WEST SUSSEX COUNTY COUNCIL CONSULTATION

TO:	Arun District Council FAO:Simon Davis
FROM:	WSCC - Highways Authority
DATE:	9 February 2022
LOCATION:	Land South of Summer Lane Pagham
SUBJECT:	P/6/22/PL Material change of use of 7.5 hectares of agricultural land to a public park comprising public allotments and open space. This application is a Departure from the Development Plan, affects a Public Right of Way and is in CIL Zone 5 (Zero Rated) as other development.
DATE OF SITE VISIT:	n/a
RECOMMENDATION:	More Information
S106 CONTRIBUTION TOTAL:	n/a

*Indicative Site Layout Plan with Site edged red
Not to Scale*

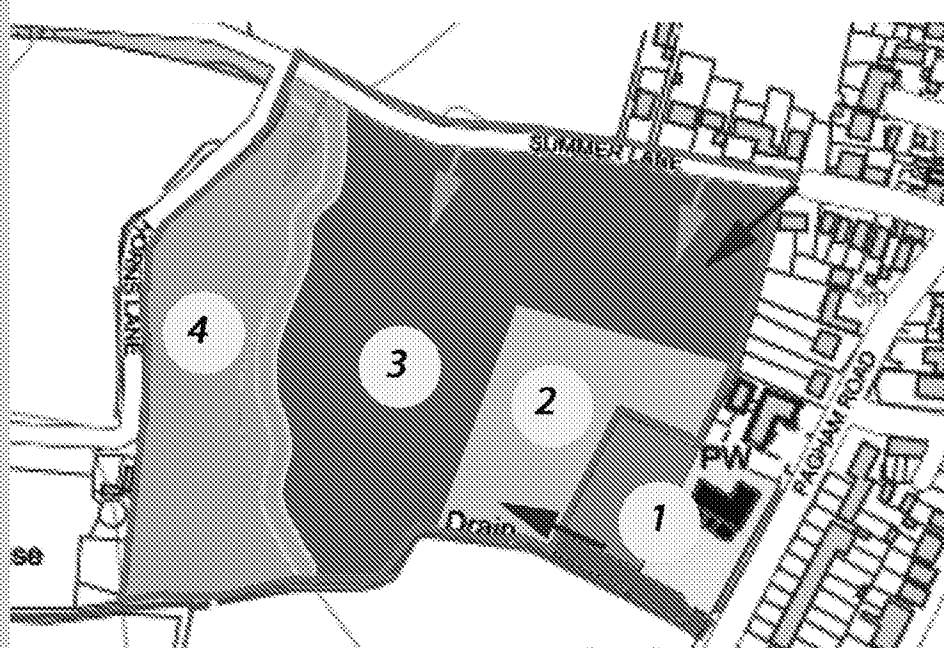
Related to access, the application form implies that no car parking is to be provided. Unless an existing area of car parking is to be used (which would need to be confirmed), car parking would be sought for the allotments. The number of parking spaces would be dependent on the number of allotments, which doesn't appear to be stated. It would be expected that some indication would be given of the location of any parking area within the site along with the number of spaces and an indicative means of access.

In summary, the general principle of development is considered acceptable but details should be sought in regards of car parking.
